County of Bernalillo

RE: Grading and Drainage Plan for Alex Paint & Body (L11-D22) (PWDN 10024)
Dated March 19, 2001

RE: Grading and Drainage Plan for Alex Paint & Body (L11-D22) (PWDN 10024)
Dated February 18, 2001

I have reviewed the referenced drainage plan received February 26, 2001 and forward the following comments. These comments are a compilation of comments from the City, Bernalillo County, and AMAFCA.

Alex Paint & Body GRADING AND DRAINAGE PLAN

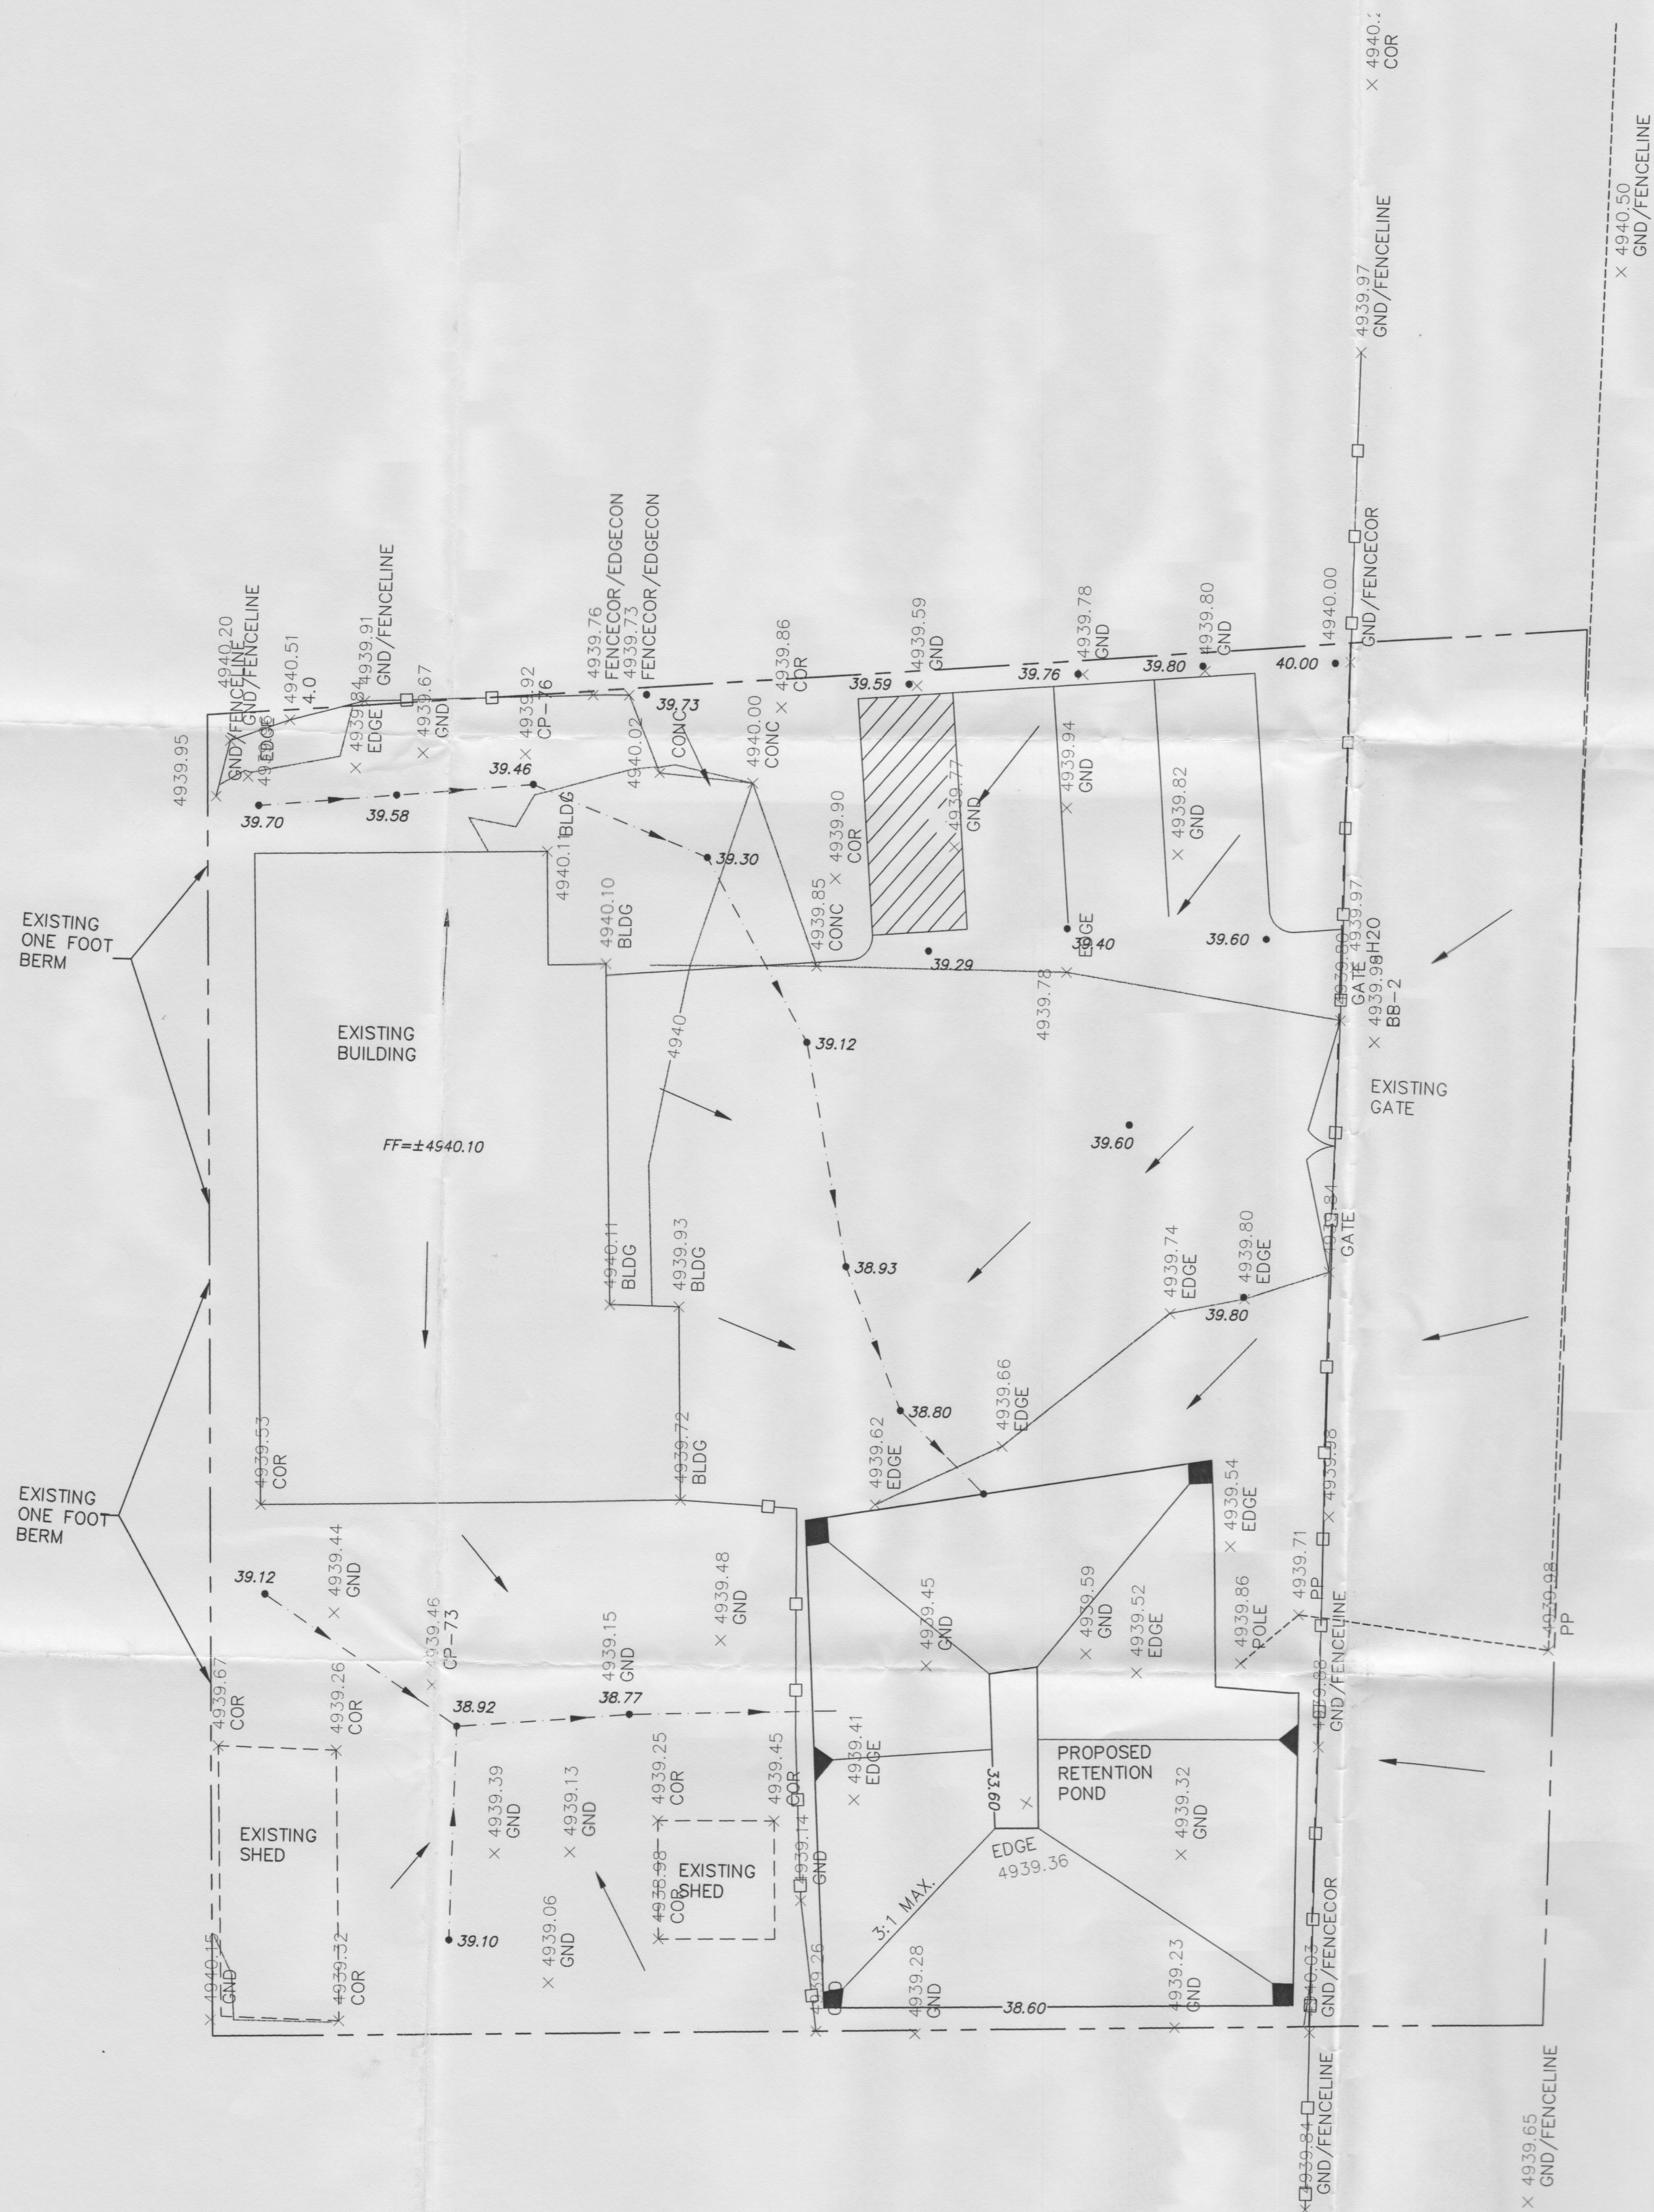
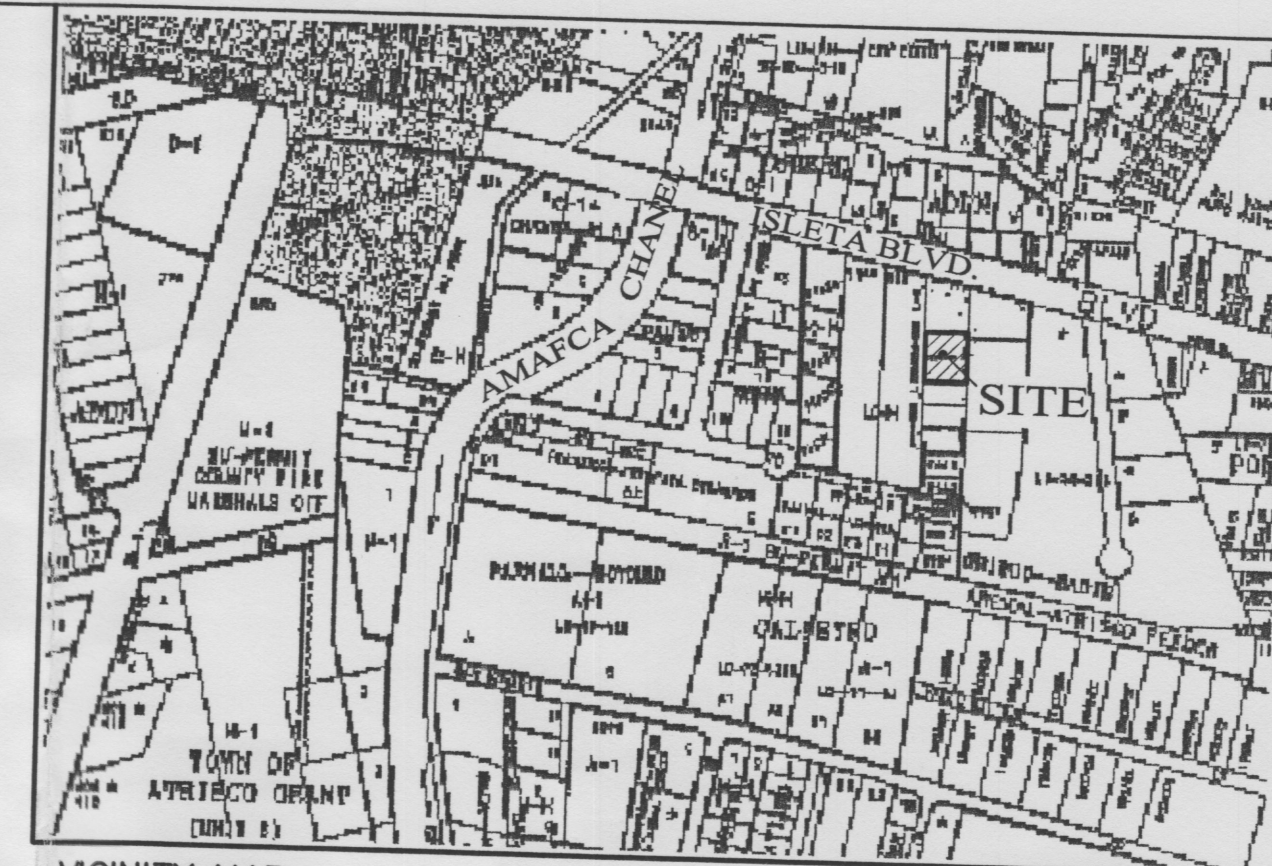
1. The size of the pond needs to include the displaced volume of the building in the flood plain.
